**RE: PA22-044 – Olympic Vista PRD – Technical Review 2**

Please refer to our responses below which address all review comments received from the City of Marysville on May 16th, 2023, regarding the Olympic Vista PRD proposal resubmittal. You will find the markup comments listed in the order that they were written followed by our response in *italics*.

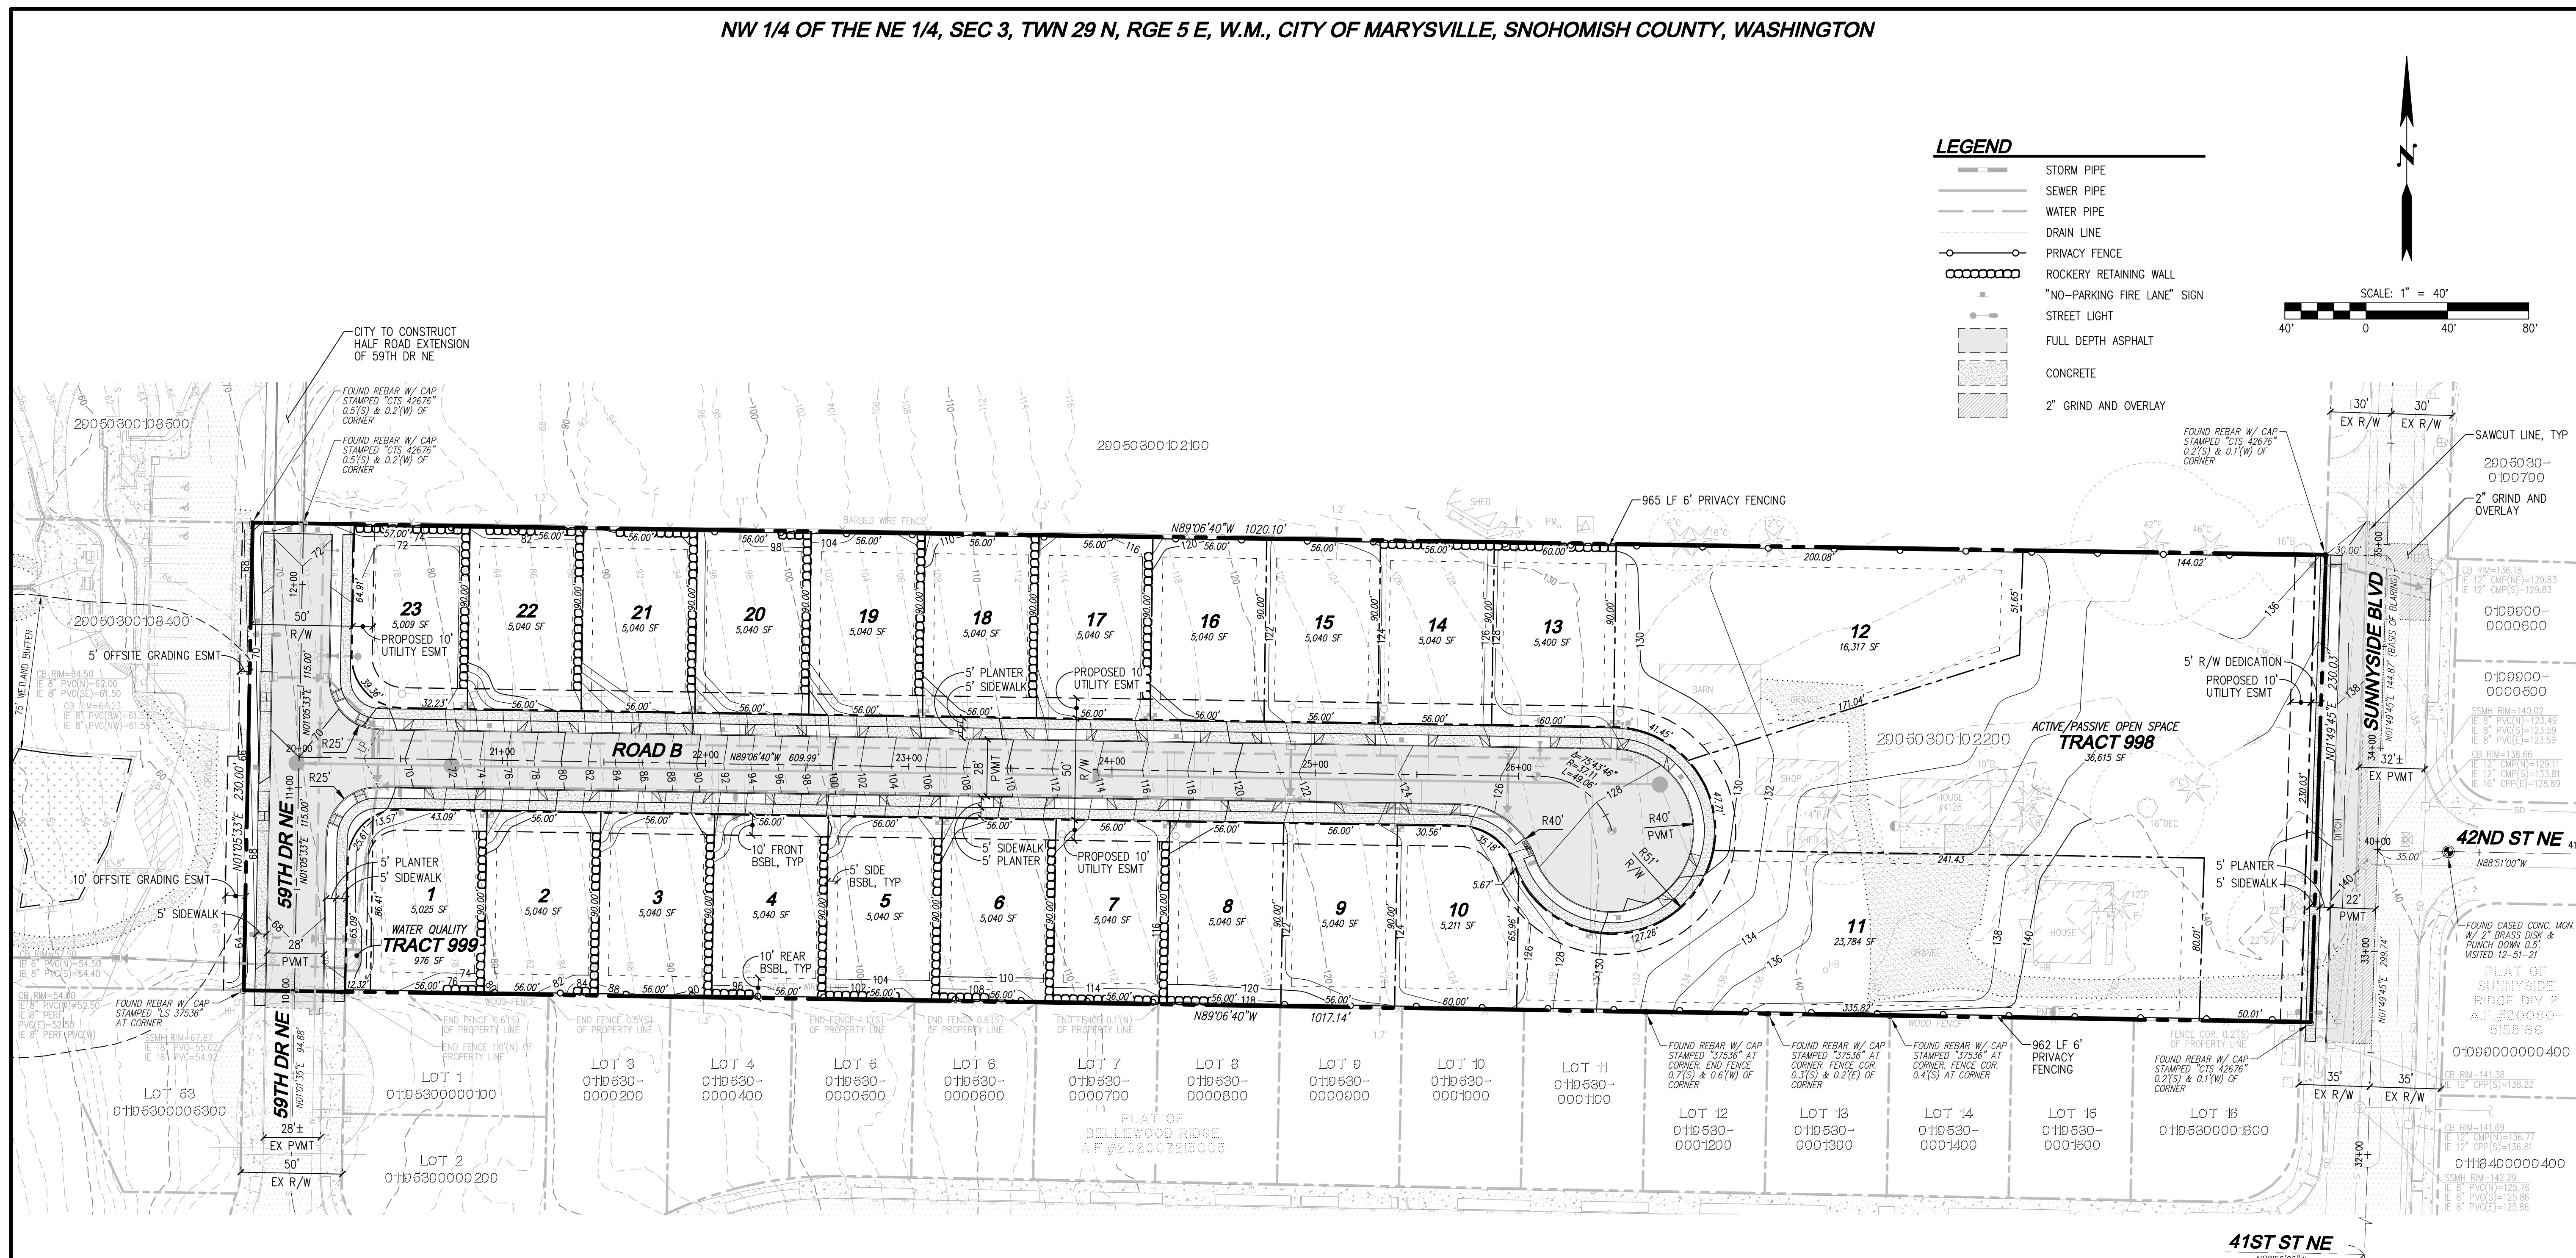
2. According to the Open Space Calculations table on sheet 2, required open space is 0.64 acres (27,843 SF) and total open space provided is only 0.42 acres (18,457 SF). Please revise the table on the site plan to accurately display open space quantities.

***Response: The table has been revised to show the correct values. The previously submitted table showed typos for the open space provided.***
